DEVELOPMENT REVIEW BOARD – SPEED MEMO

DRB CASE NO: 1009521

8. **Project# 1009521**
12DRB-70372 MINOR - PRELIMINARY/
FINAL PLAT APPROVAL

PRECISION SURVEYS INC agent(s) for ROBERT PEREA SR., ROBERT PEREA JR., MELINDA PEREA request(s) the above action(s) for all or a portion of Lot(s) 1, 2, & 3, Block(s) 1, **GARDEN PARK TRACT** zoned RA-2, located on 12TH ST / MATTHEW BETWEEN LOS ARBOLES AND GARDEN PARK containing approximately .6948 acre(s). (G-13 & 14)*[Deferred from 12/12/12]***WITHDRAWN.**

Matthew Boulevard, NW
(60' R.O.W.)

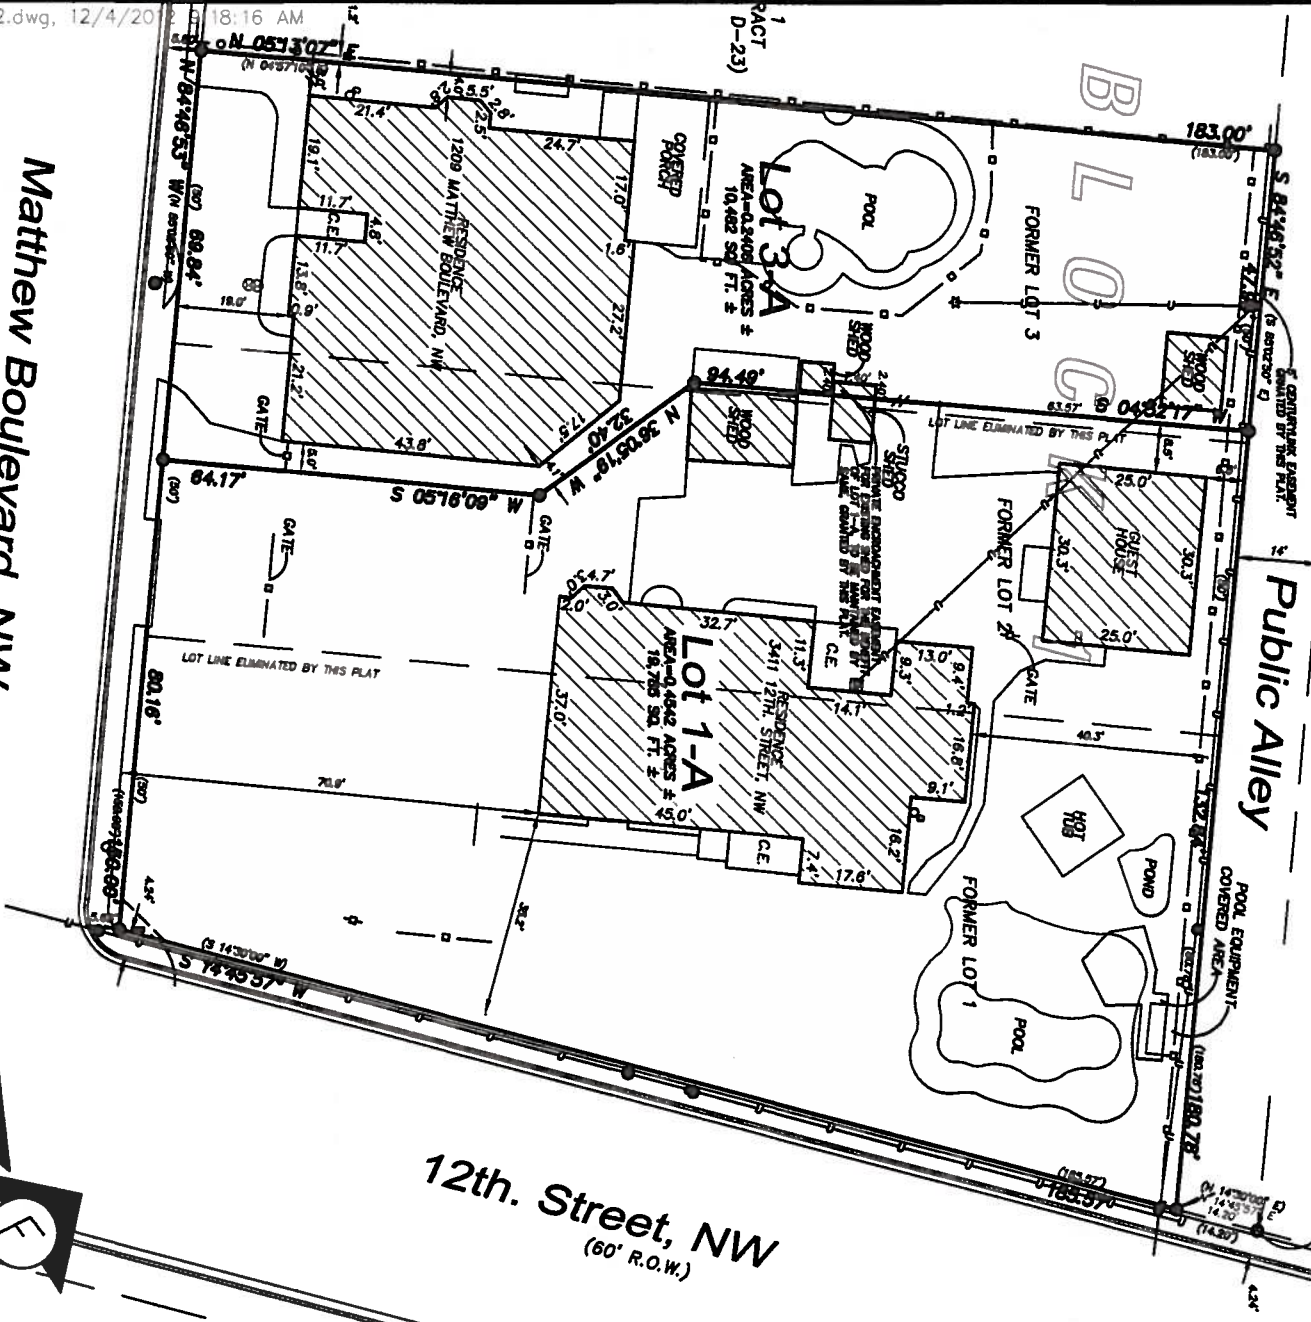
Provide an exhibit showing the location of sidewalk and defining the distance from face of curb to the property line. Right of way dedication may be required.

12th Street is a minor arterial in this area. Arterial roadways should have a distance of 12 feet from back of curb to the property line (see Table 23.2.1A of the *DPM*). If existing conditions make a right of way dedication difficult, please clarify.

Local roadways should have a distance of 10 feet from back of curb to the property line (see Table 23.2.1A of the *DPM*). If existing conditions make a right of way dedication difficult, please clarify.

Per the *Development Process Manual*, Table 23.3.3, the intersection of a minor arterial and a local roadway requires a radius of 30 feet. Right of way dedication will be required. A public traffic signal easement is not appropriate.

Fencing and walls are shown within City of Albuquerque right of way along 12th Street and Matthew Boulevard. It is recommended that these obstructions be relocated. Otherwise, a revocable permit (contact: Jane Rael, 924-3992) is required. Please note that a revocable permit will not be appropriate if the existing fencing/walls interfere with the clear sight.
